55 Riverview

Philip DiPierro <pd@portlandmaine.gov>
To: Ann Machado <amachado@portlandmaine.gov>

Wed, Nov 15, 2017 at 5:31 PM

TYPICAL RIPRAP SLOPE
NOT TO SCALE

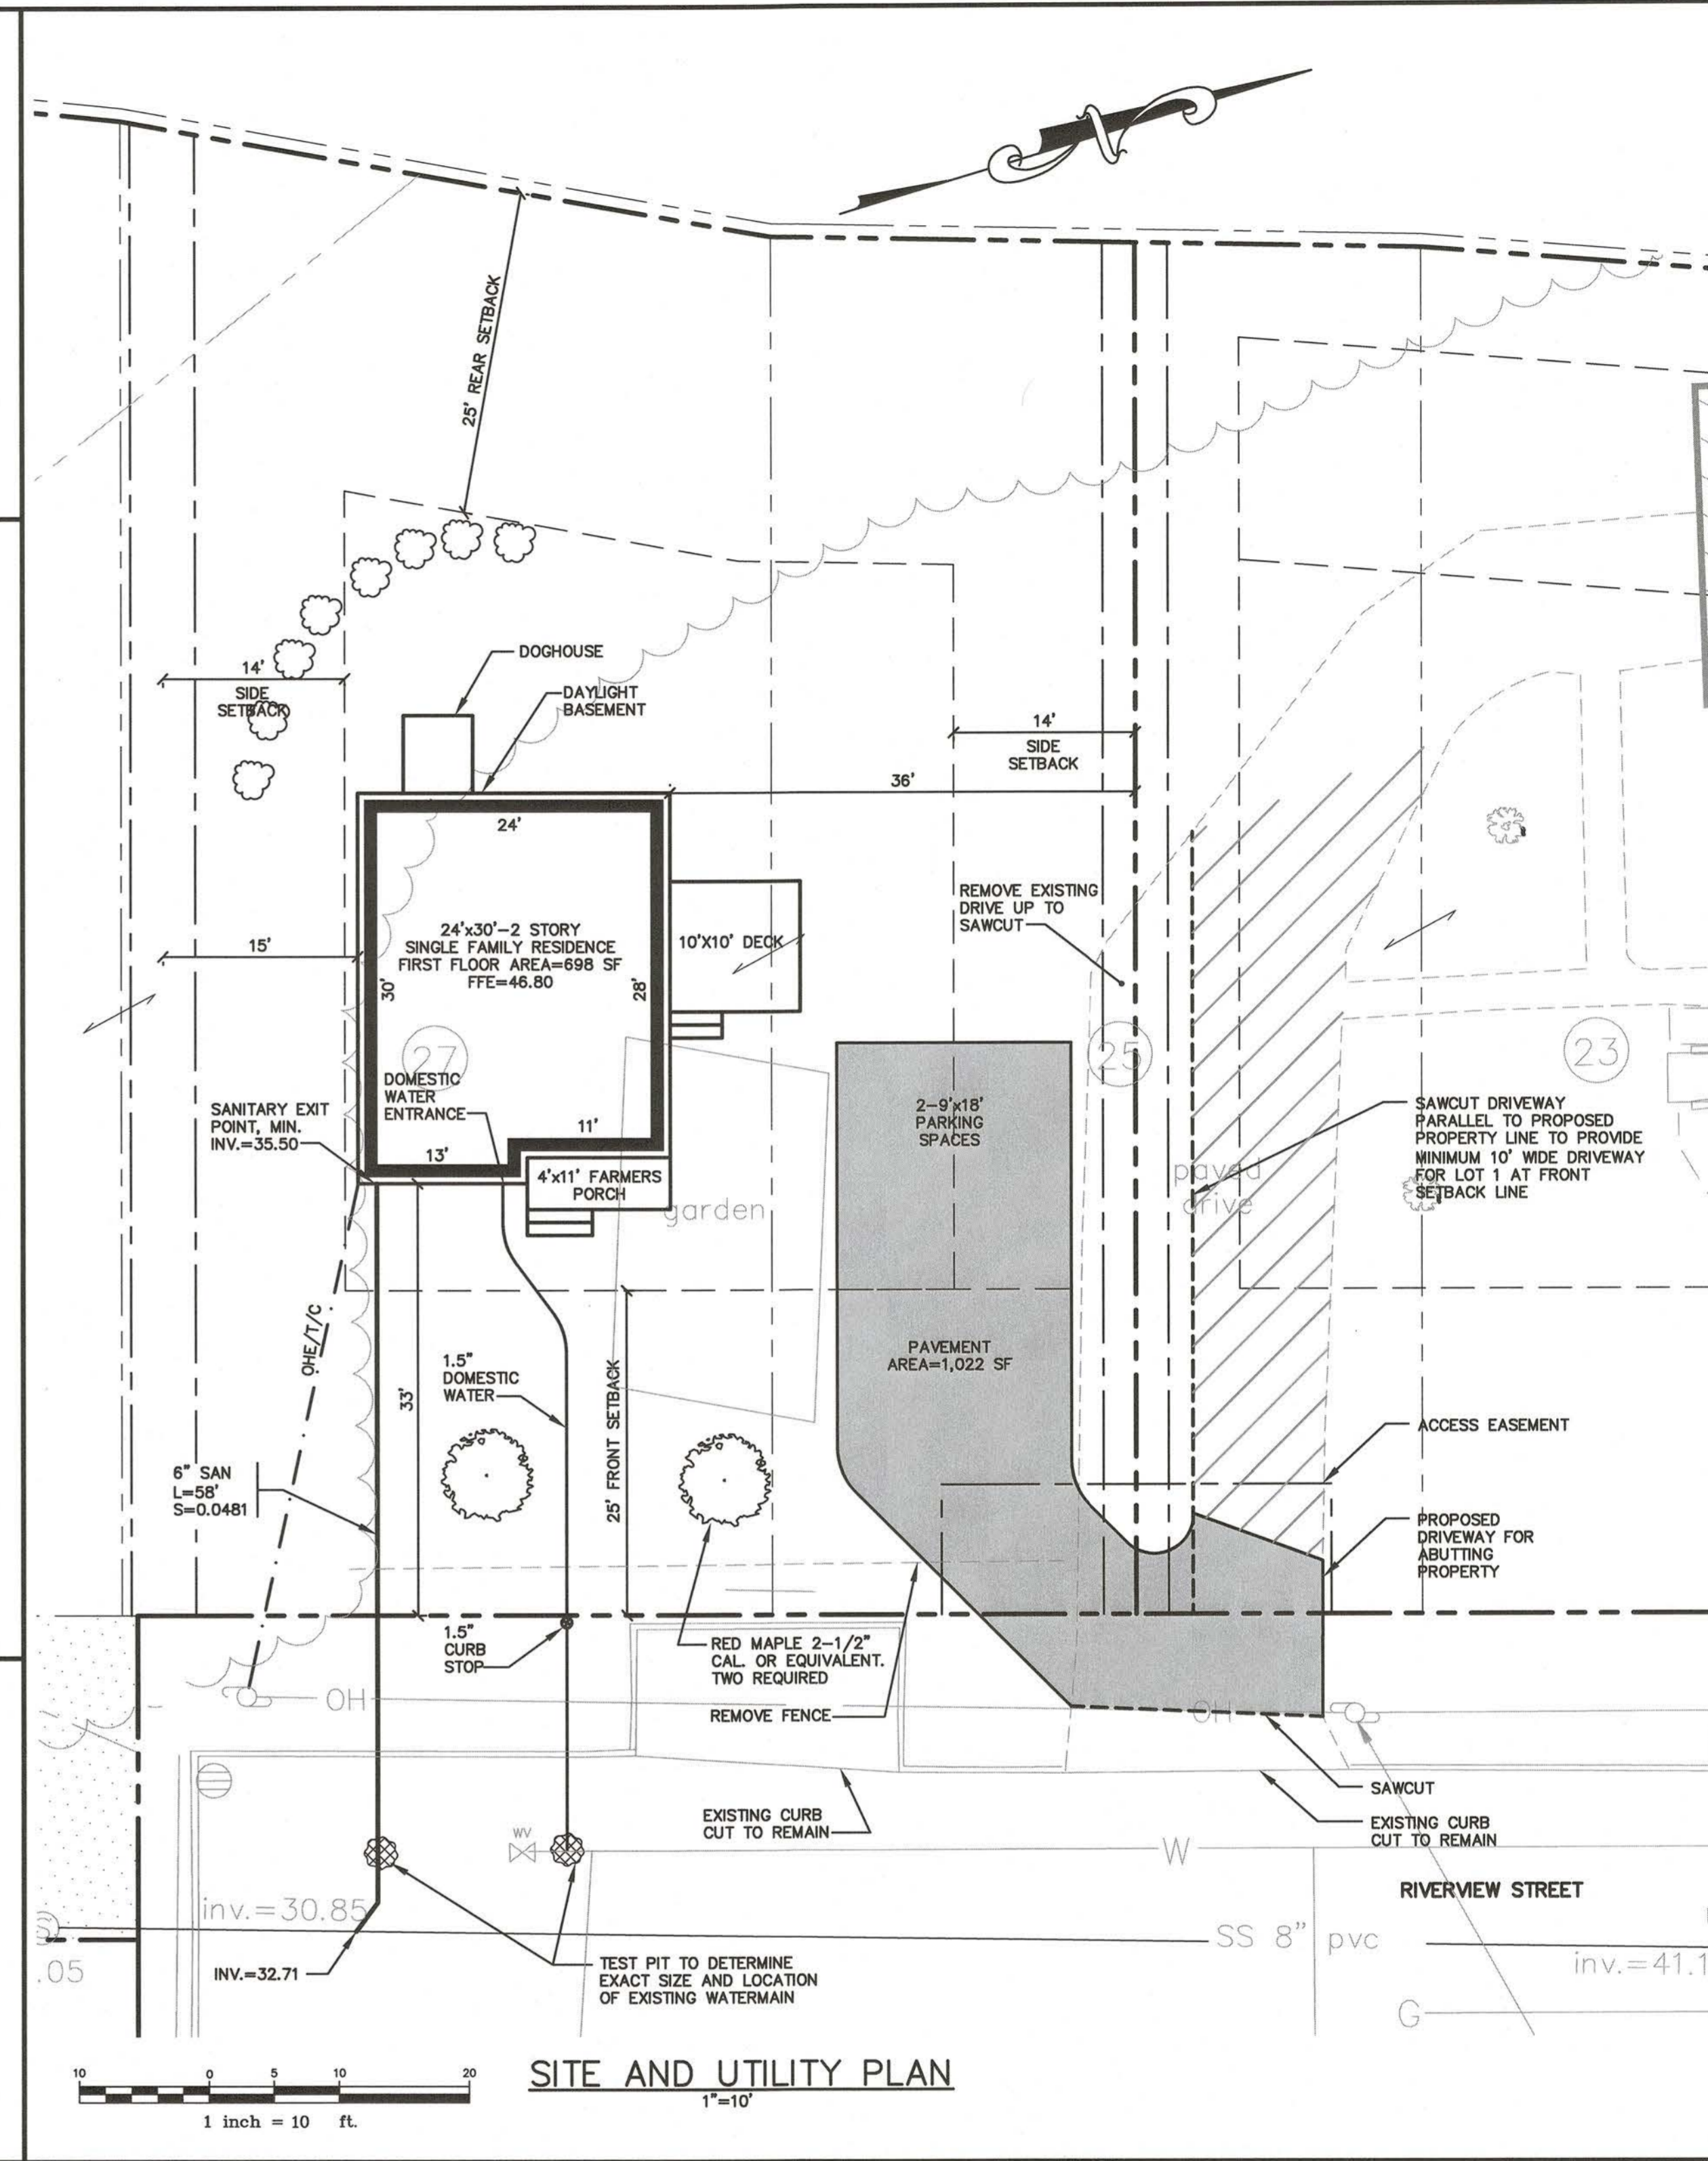
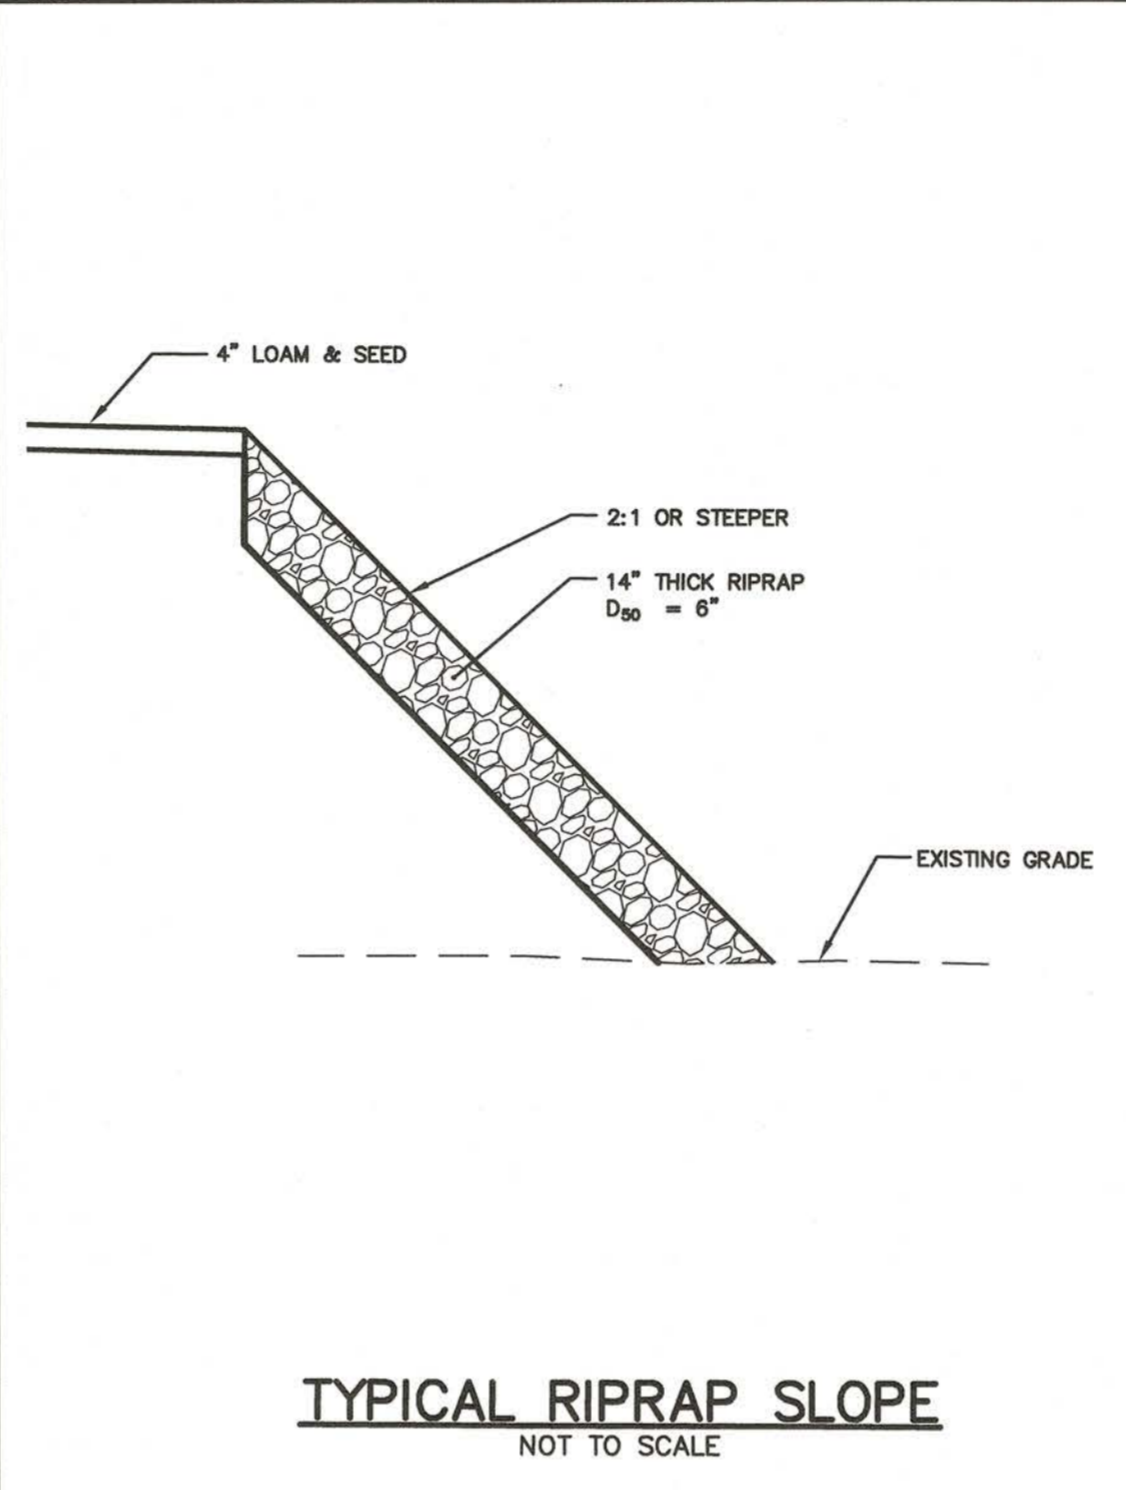
Hi Ann, I looked at the site today. The slope is stable and no erosion was noted. Some of the riprap has slumped, but vegetation has grown in these areas creating a stable slope. The riprap installation probably could have been done better, but it appears to be stable at this time. The slope for this site appears to be as stable as the rest of the slope for the abutting homes. See pics attached.

I have no issues with the site at this time.
